**KIRKLEES METROPOLITAN COUNCIL
INVESTMENT & REGENERATION SERVICE**

DELEGATED DECISION TO DETERMINE PLANNING APPLICATIONS

Reference No:	2025/62/90203/E
Site Address:	73, Burnley's Mill Road, Gomersal, Cleckheaton, BD19 4PH
Description:	Erection of single storey rear extension
Recommending Officer:	Faiza Bano

HOUSEHOLDER DELEGATED REPORT

Drawing No.
(0112) - P200

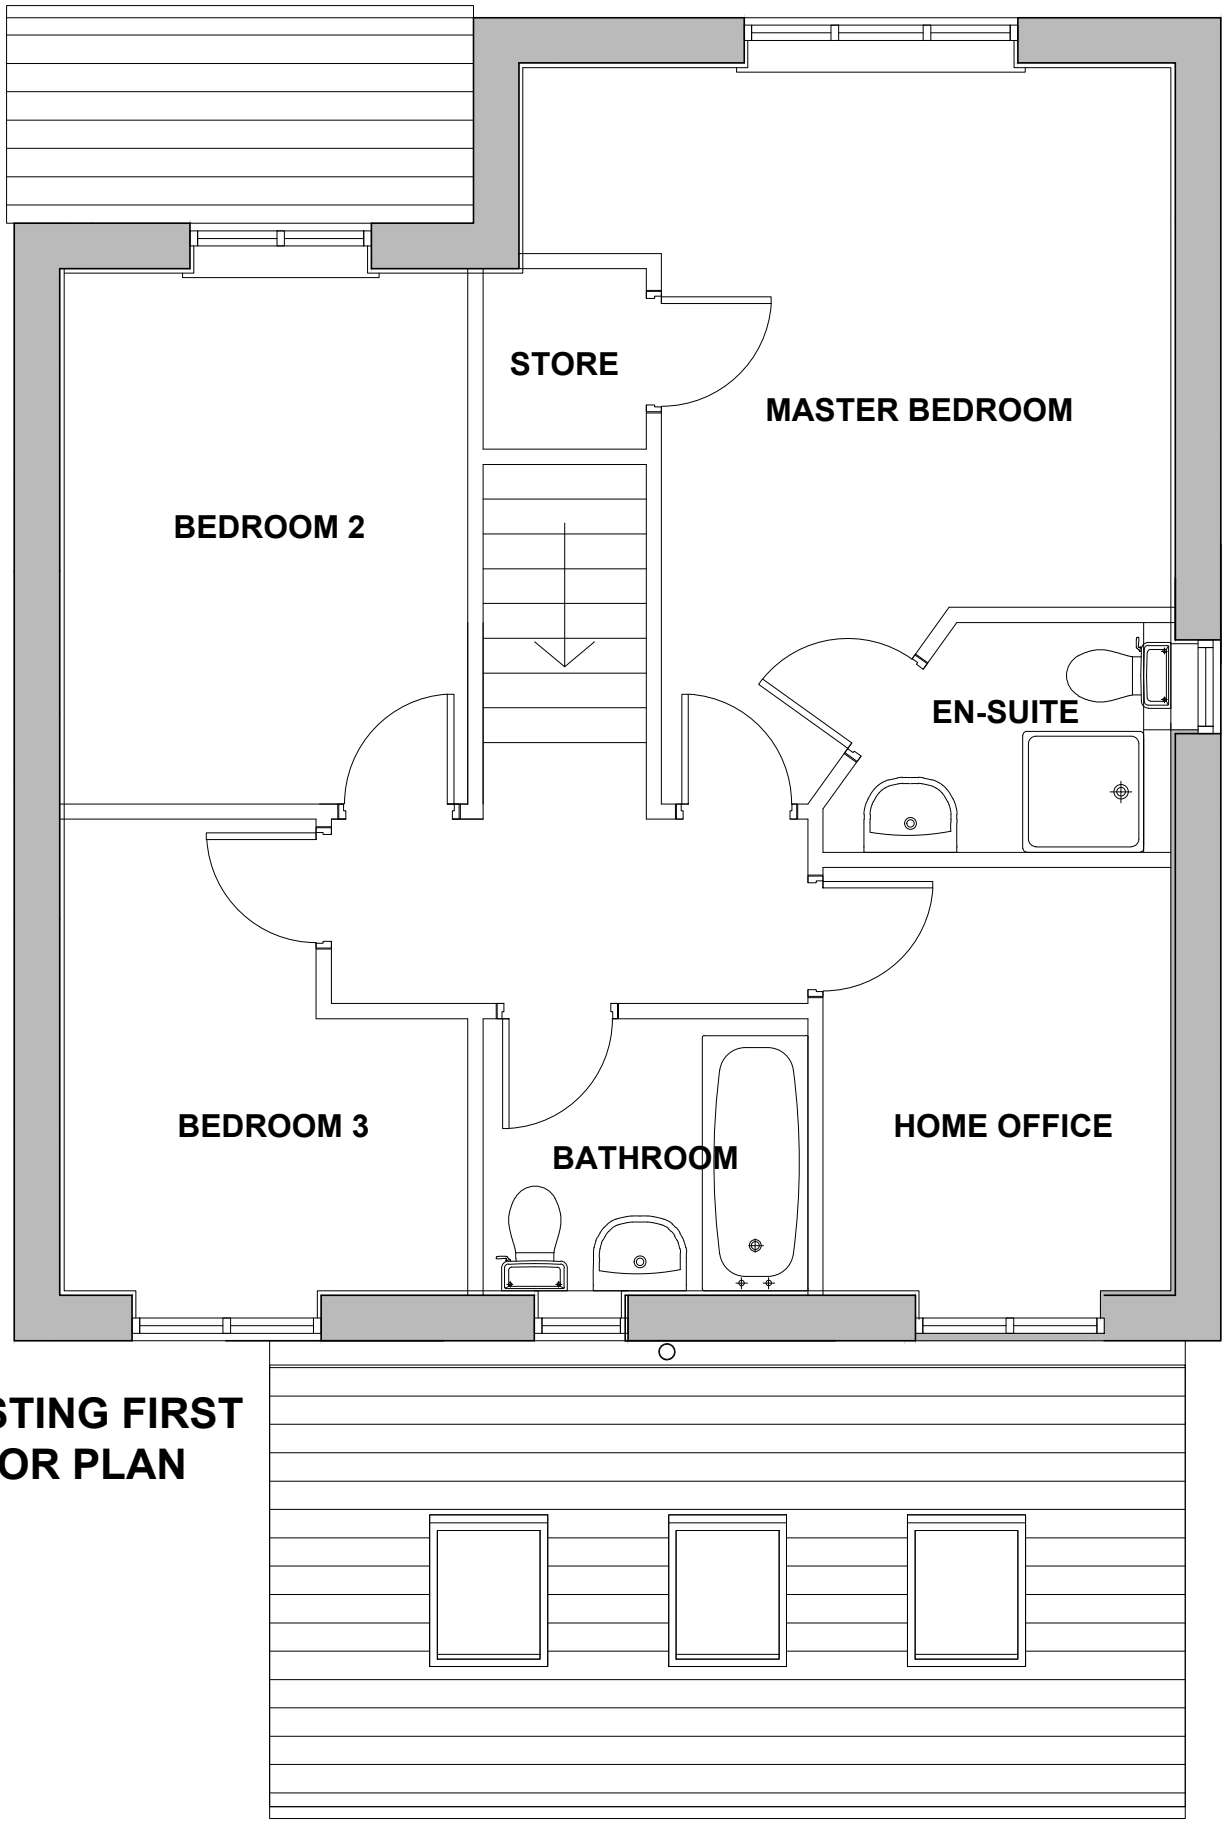
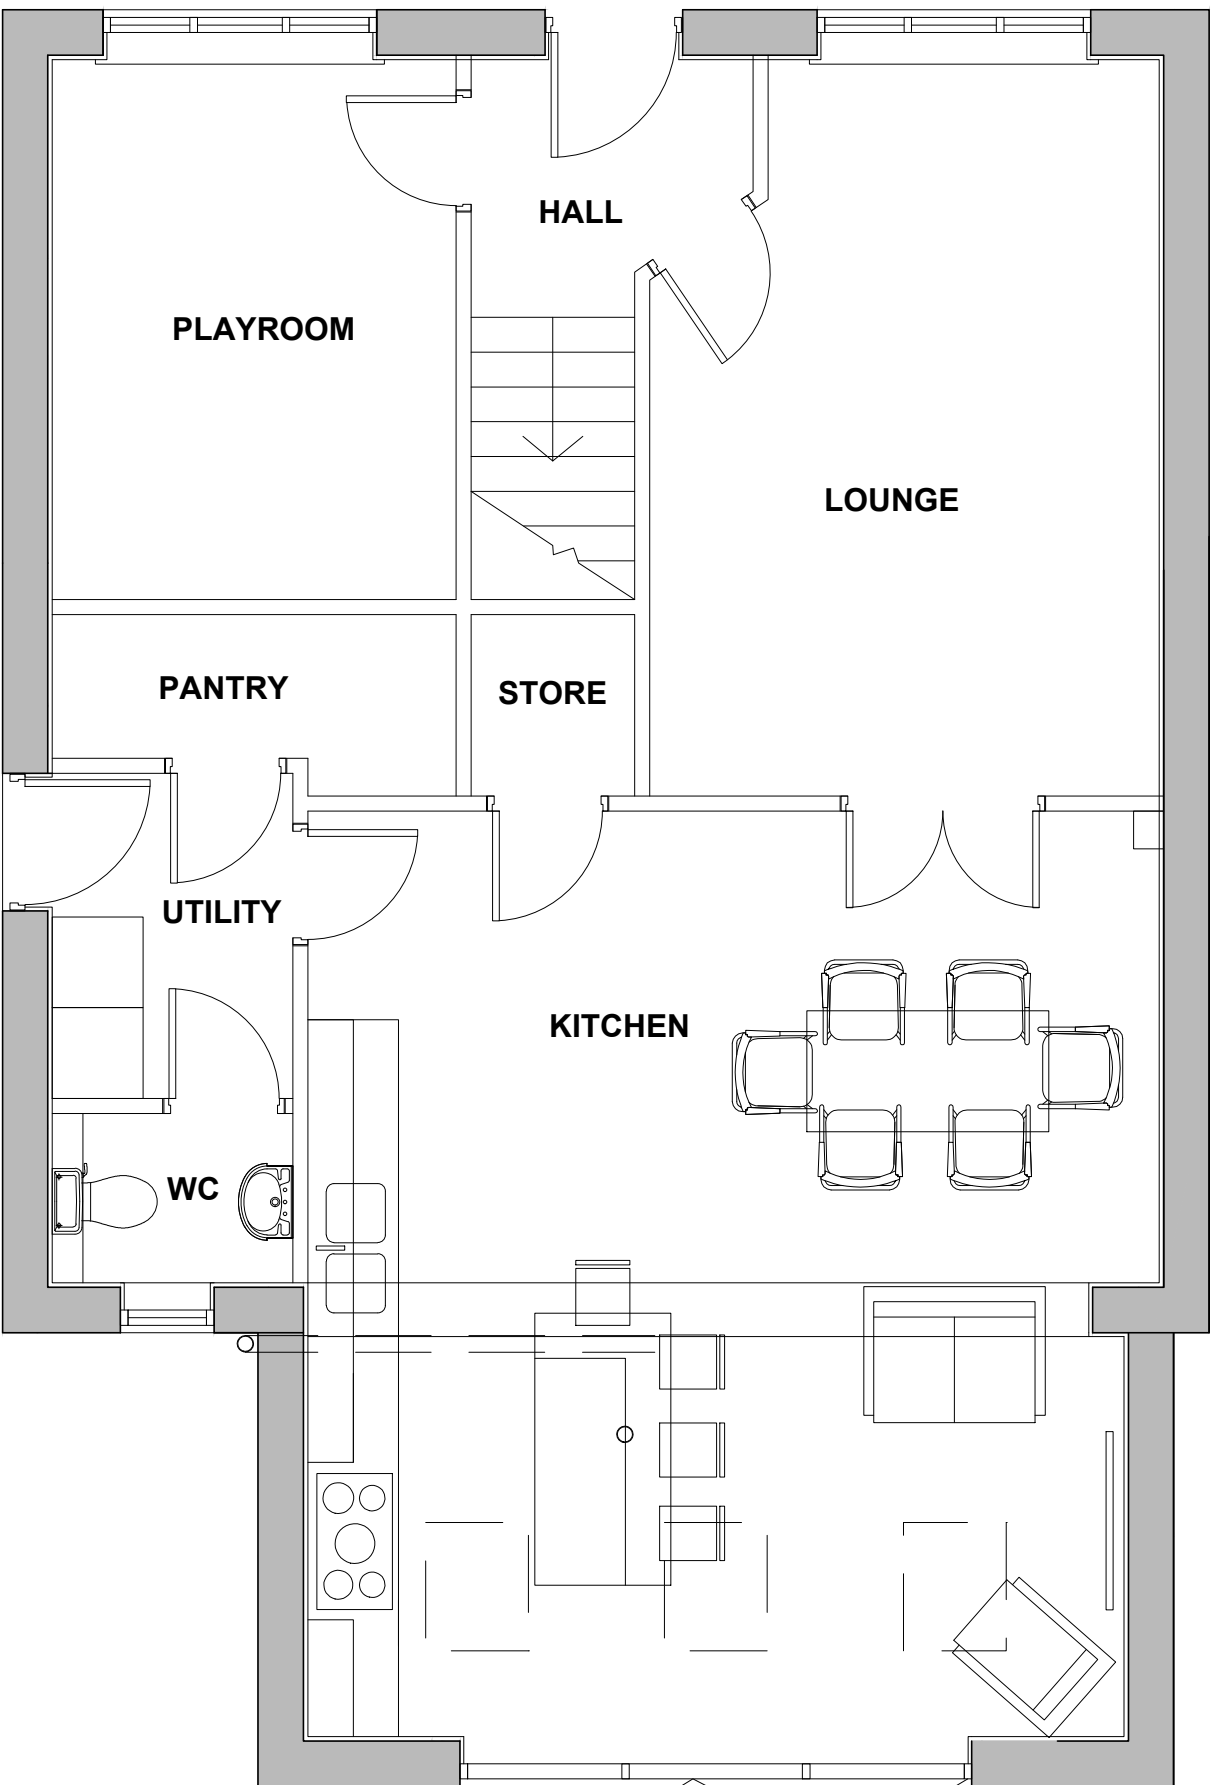
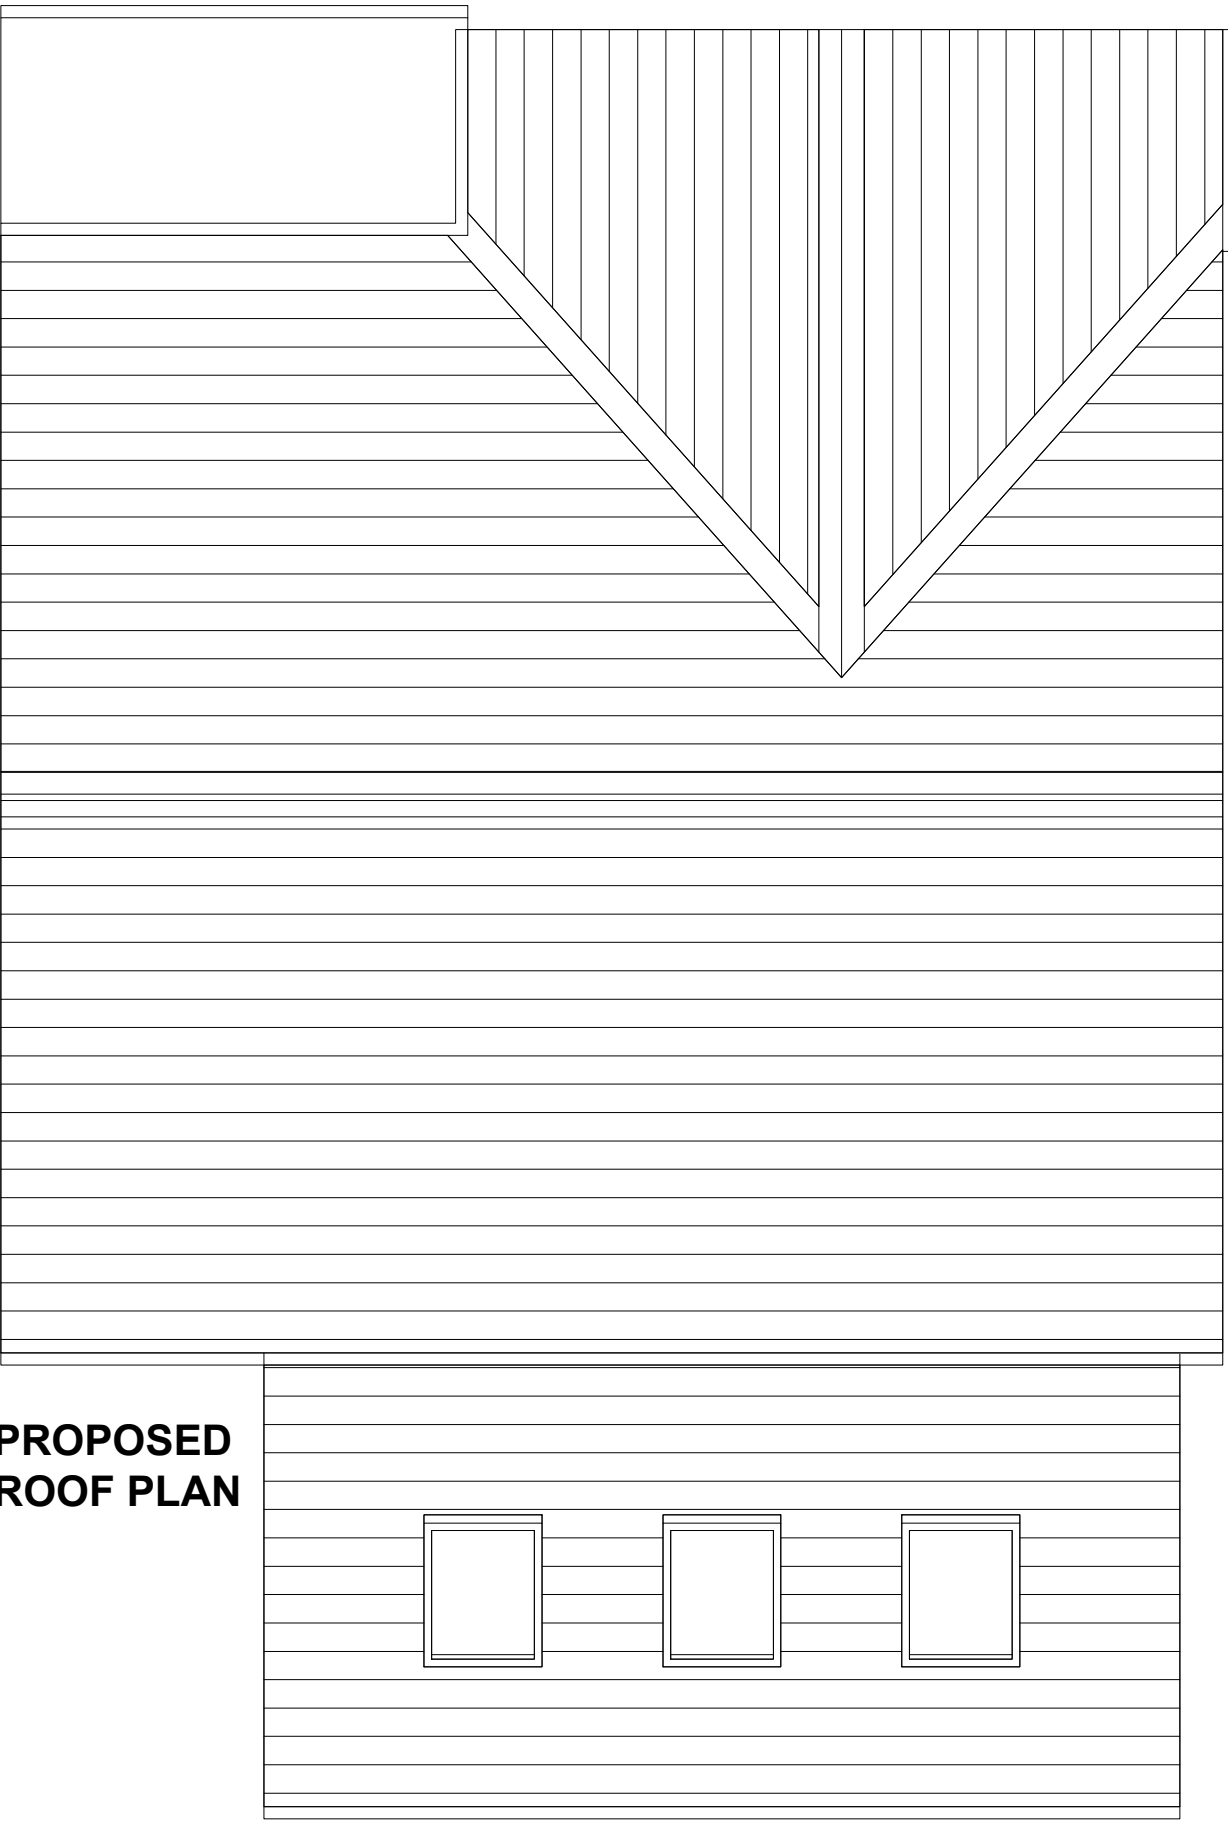
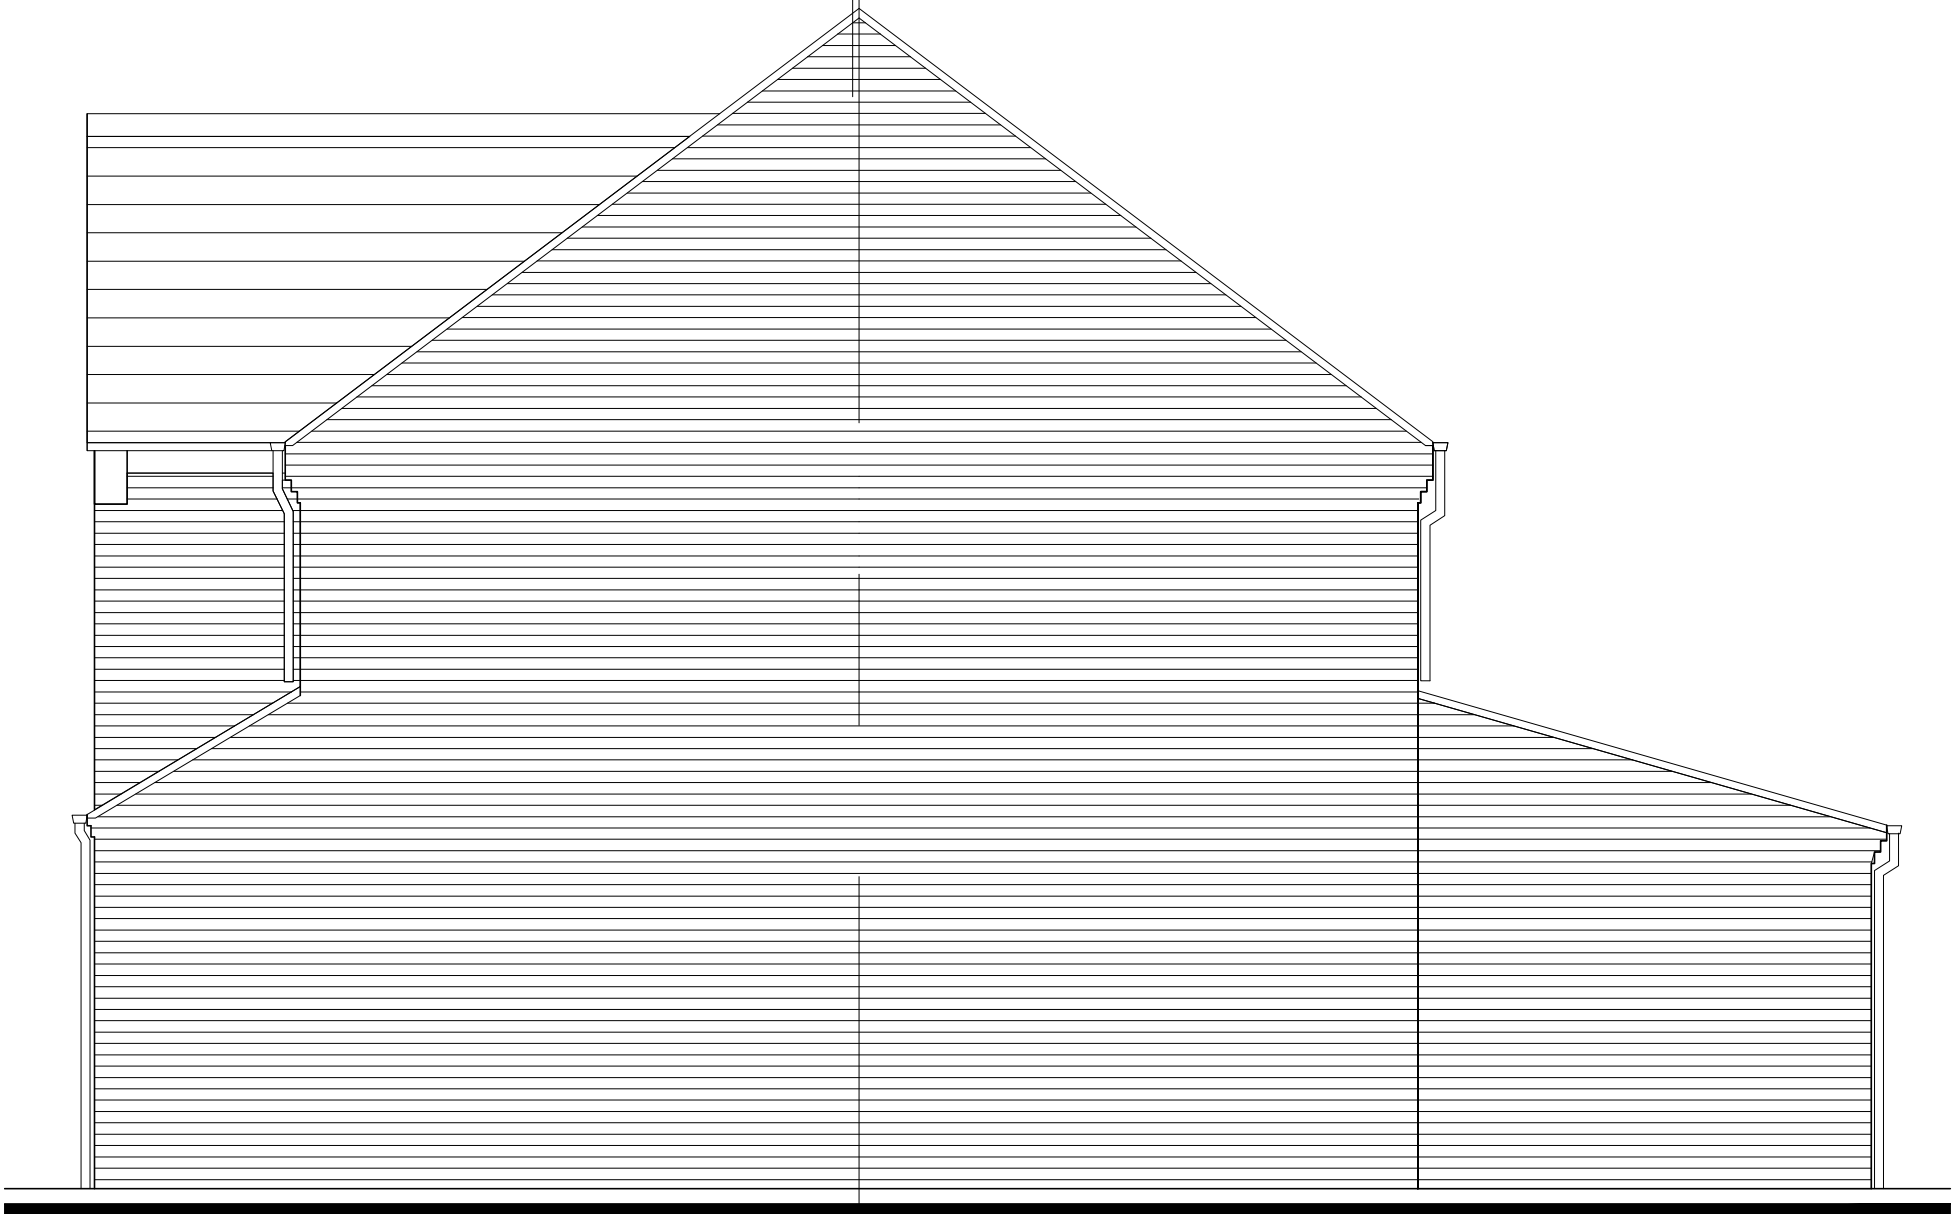
where they exceed 3m in length the eaves height should generally not exceed 2.5 meters; and	Extension does not exceed these limits.	
retain a gap of at least 1 metre from a property boundary, such as a wall, fence or hedge.		No – the extension does not retain a gap along the south east boundary, however, this reflects the design of the dwelling which is constructed up to this boundary.

Roof style	<ul style="list-style-type: none"> • KDP 1 and 2 of the SPD • Policy LP24 Design (a), (c) and (d) of the KLP • Chapter 12 of the NPPF 	Lean-to roof style – acceptable as it is in-keeping with the original roof style of the host property.	✓
Window proportions	<ul style="list-style-type: none"> • KDP 1 and 2 of the SPD • Policy LP24 Design (a), (c) and (d) of the KLP • Chapter 12 of the NPPF 	Modest size windows in rear extension, including roof lights, which would be in-keeping with existing building.	✓
Accessibility for all users	<ul style="list-style-type: none"> • KDP 17 of the SPD • Policy LP24 Design (f) • Chapter 12 of the NPPF 	Private domestic extension which would provide easy access into the main house.	✓

- 75 Burnley's Mill Road – this property is the neighbouring property closest to the proposed extension. The proposed single-storey rear extension, projecting 3 metres with an eaves height of 2.3 metres and designed with a lean-to roof, will have minimal impact on number 75. The opening closest to the boundary is considered non-habitable and therefore there will be no impact in terms of loss of lights, outlook and overshadowing/overbearing.
